Medworth Energy from Waste Combined Heat and Power Facility

PINS ref. EN010110
Document Reference: 10.4
Revision: 1.0
Deadline: 2
March 2023

Applicant's Response to NCC and KLWN's Local Impact Report

**Figure 10.1i**  
**New Bridge Lane access design**

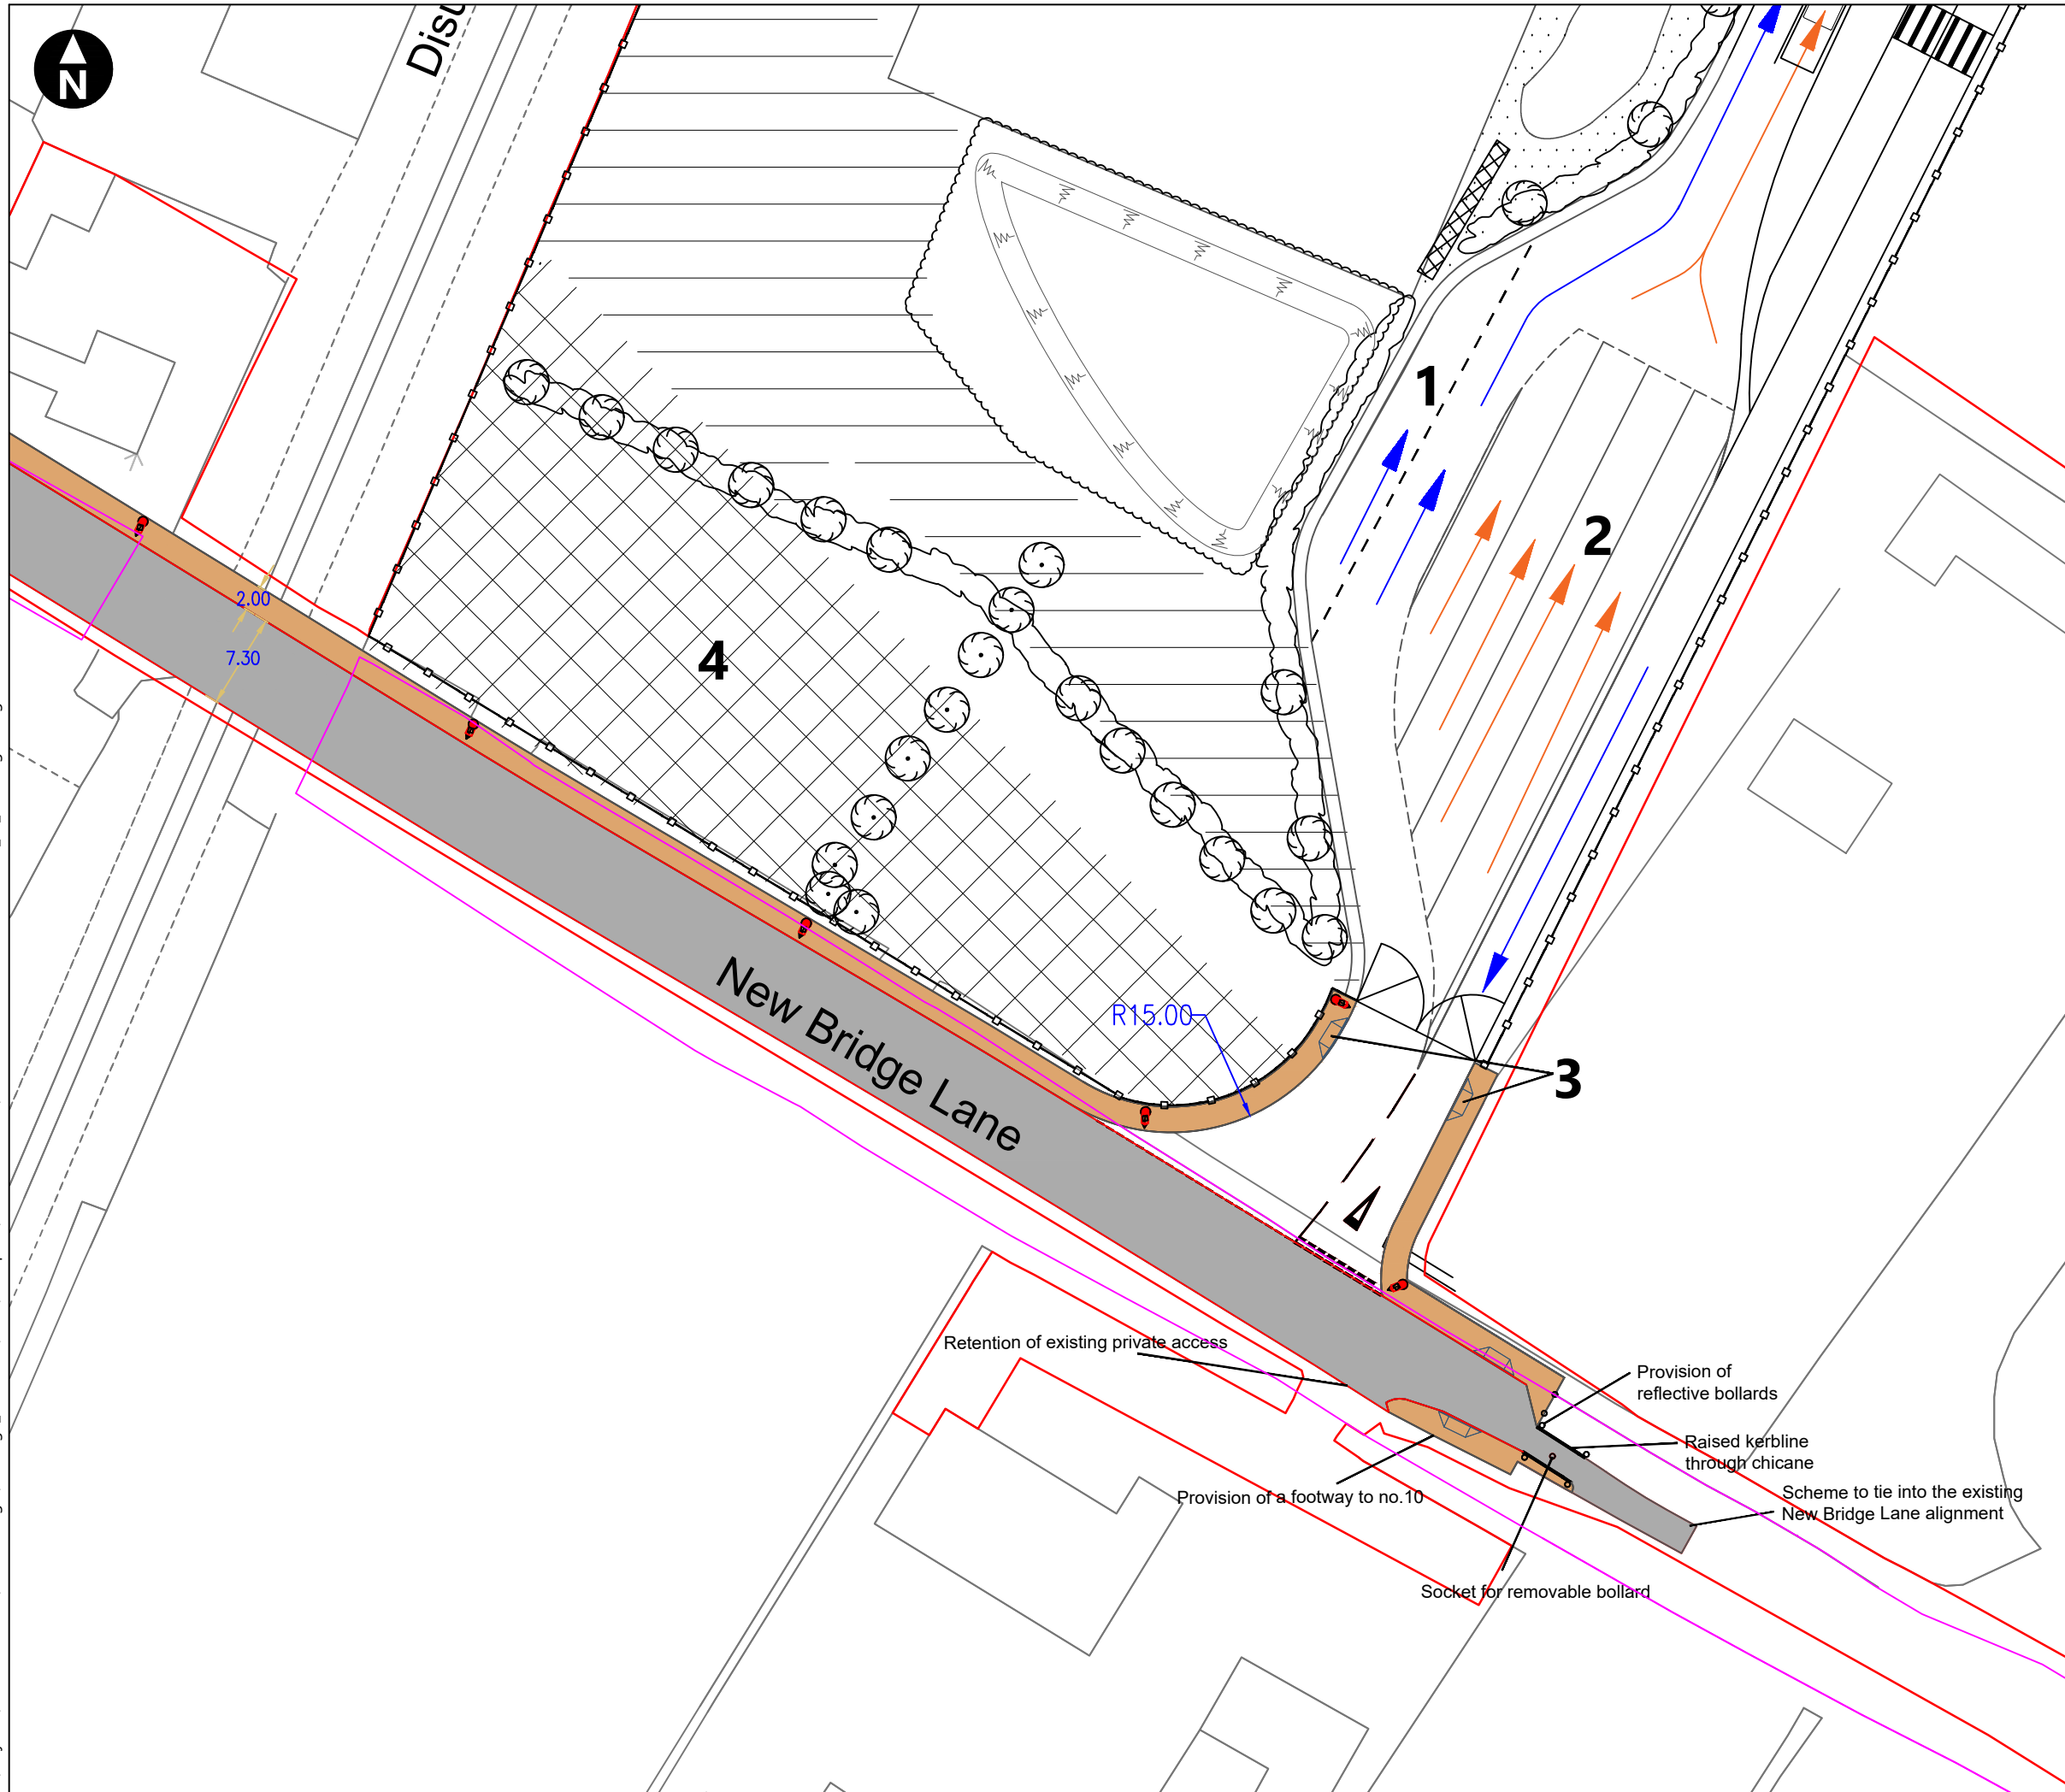
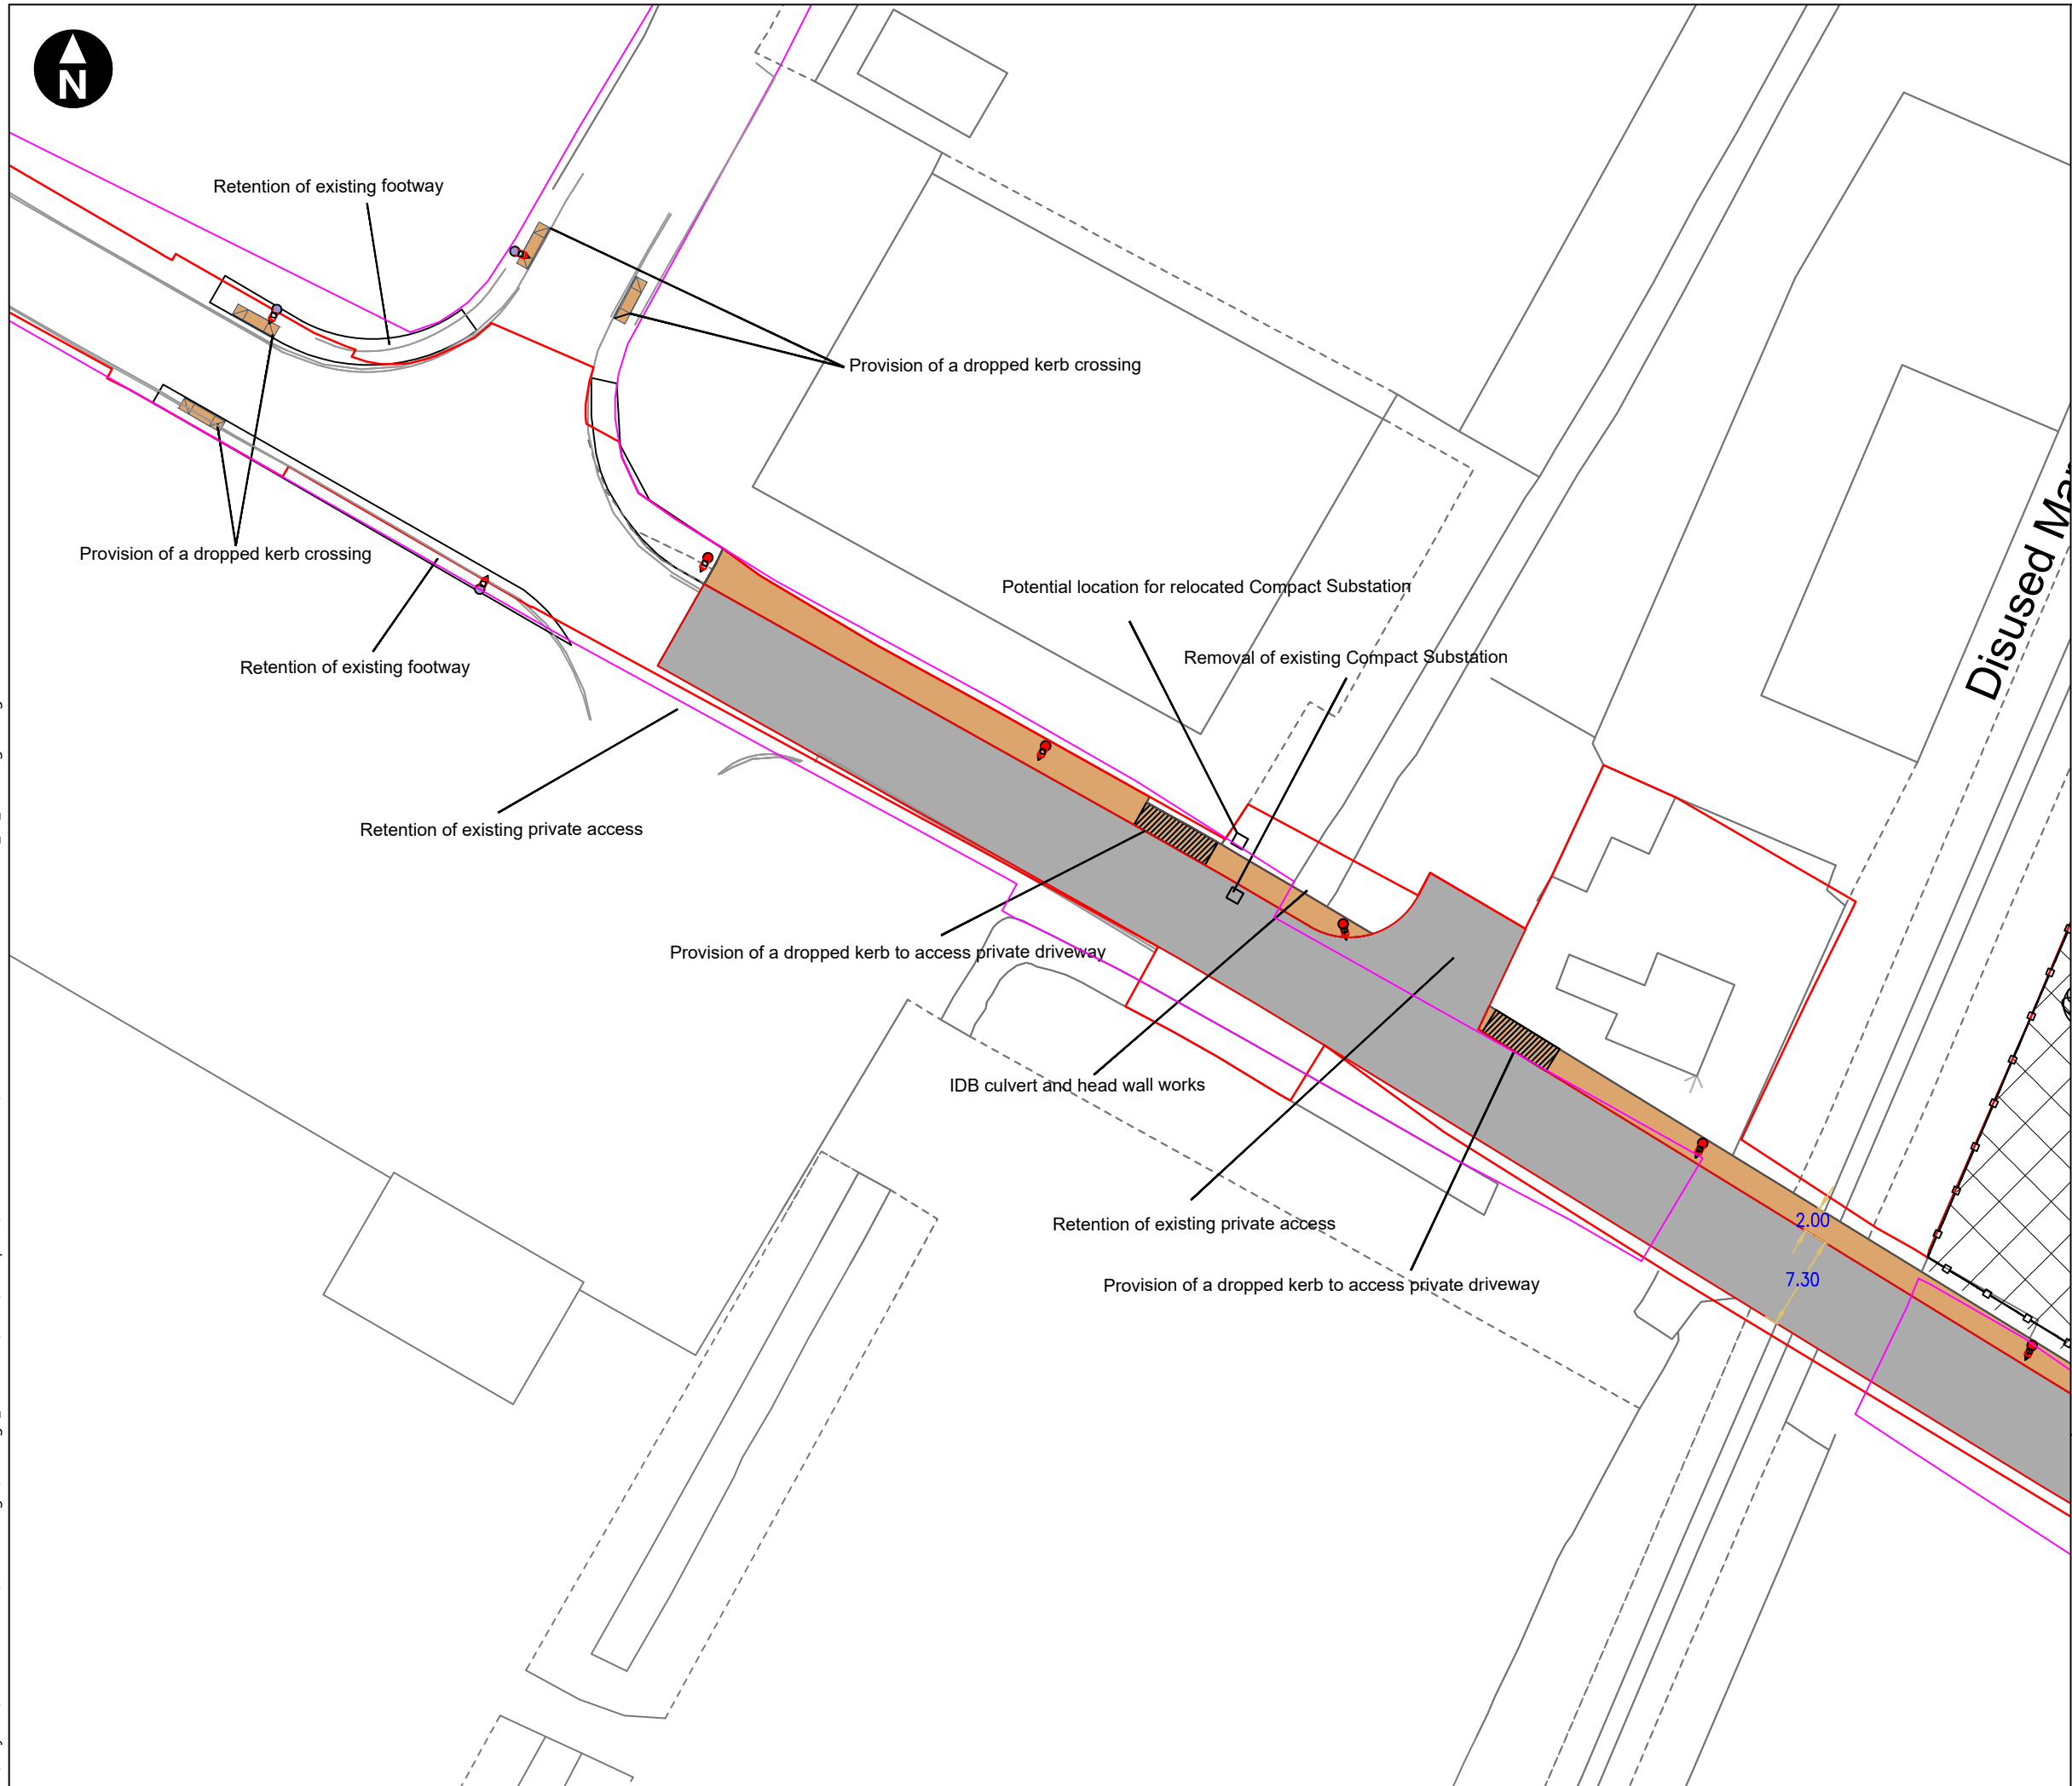
8.15	Requiring the new access route via the Cromwell Road link as early as possible would greatly reduce the impact on West Norfolk as the route is almost completely through commercial land, passing approximately four dwellings. This would be welcomed as a condition.	<p>The impact on West Norfolk Receptors from vehicle noise related to the development is assessed in Table 7.15 of ES Chapter 7 Noise and Vibration (Volume 6.2) [APP-034]. All roads with KLWN residents adjacent are subject to negligible increases in traffic noise. Haul routes avoid low flow roads in west Norfolk and specifically avoid the A1101 Elm High Road/Churchill Road corridor.</p> <p>Construction HGV routing is controlled via ES Chapter 6 Traffic and Transport Appendix 6A Outline Construction Traffic Management Plan (Volume 7.15) [REP1-011]. The management plan is secured by Draft DCO (Volume 3.1) [REP1-007] Requirement 11.</p>

LIR Paragraph	Summary of NCC and KLWN's Comments	Applicant's response
		<p>The Applicant will access the EFW CHP Facility Site from New Bridge Lane as soon as the construction works necessary to implement it are completed. ES Chapter 3 Description of the Proposed Development (Volume 6.2) [APP-030] provides the construction programme as Graphic 3.23 Construction Programme Summary. This shows the Access Improvement works starting in Month 2 and completing in Month 7.</p>
